**United Utilities Water PLC
Developer Services & Planning**
Thirlmere House
Lingley Mere Business Park
Lingley Green Avenue
Great Sankey
Warrington WA5 3LP

Your ref: 3/2012/1106
Our ref: DC/13/470
Date: 22-FEB-13

Location: Reed Deep, Whalley Road hurst Green Lancashire BB7 9QJ
Proposal: Proposed single storey ancillary to the main dwelling

Scale 1:500

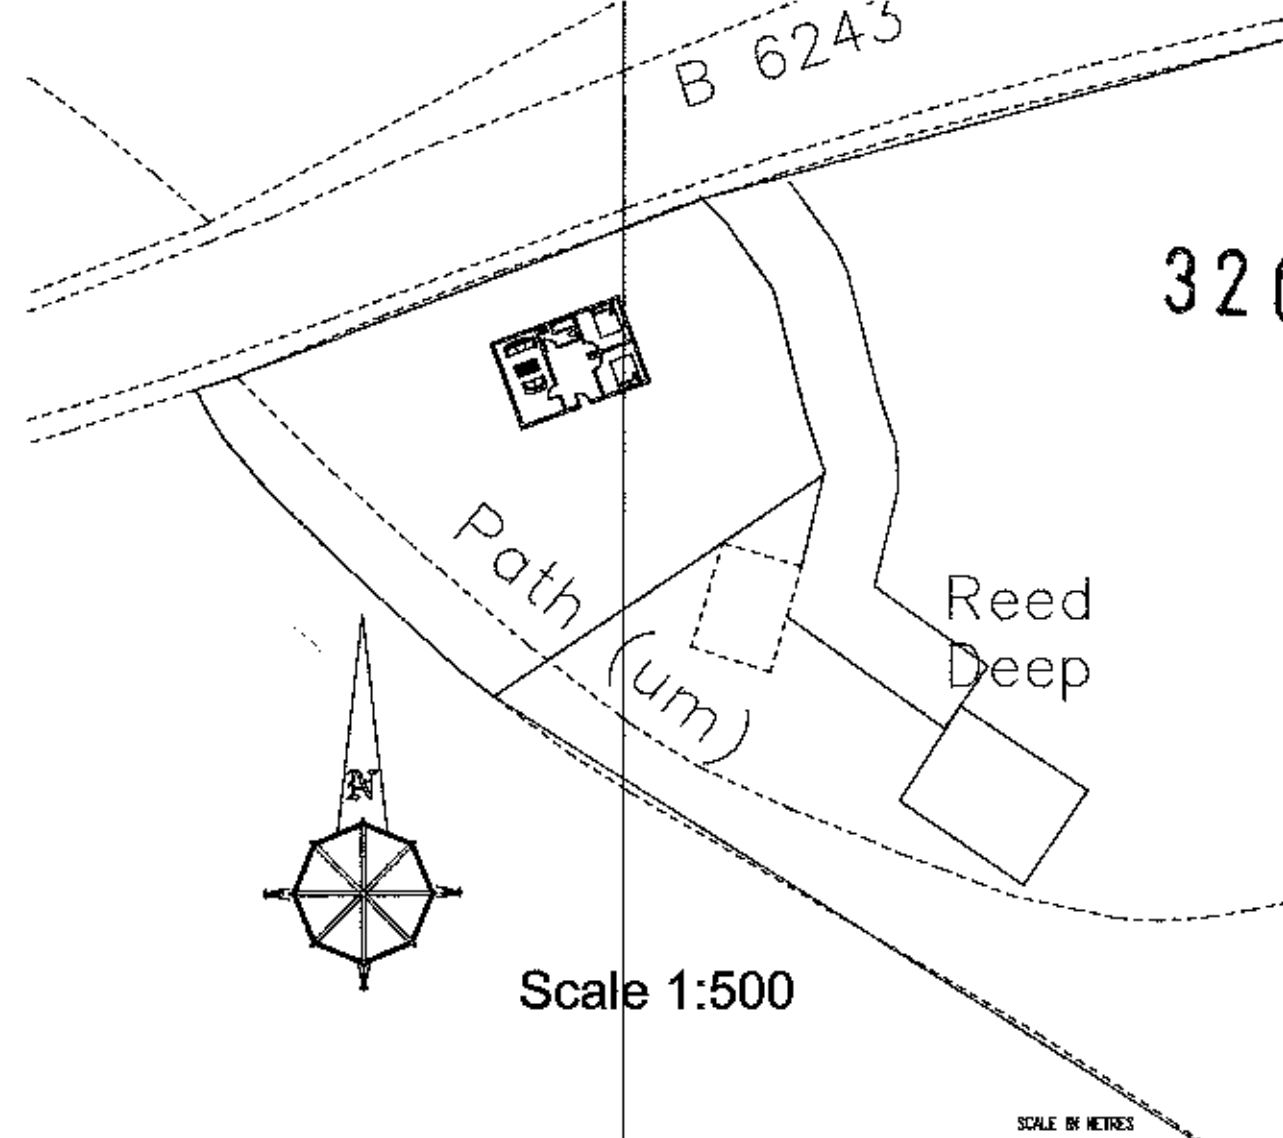
A public sewer crosses this site and we will not permit building over it. We will require an access strip width of 6 metres, 3 metres either side of the centre line of the sewer which is in accordance with the minimum distances specified in the current issue of "Sewers for Adoption", for maintenance or replacement.

Therefore a modification of the site layout, or a diversion of the affected public sewer at the applicant's expense, may be necessary. To establish if a sewer diversion is feasible, the applicant must discuss this at an early stage with Graham Perry the Developer Enquiries Analyst by email, planning.liaison@uuplc.co.uk as a lengthy lead in period may be required if a sewer diversion proves to be acceptable.

- Unless otherwise agreed in writing by the Local Planning Authority, no building shall be erected within 3 metres of any public sewer.
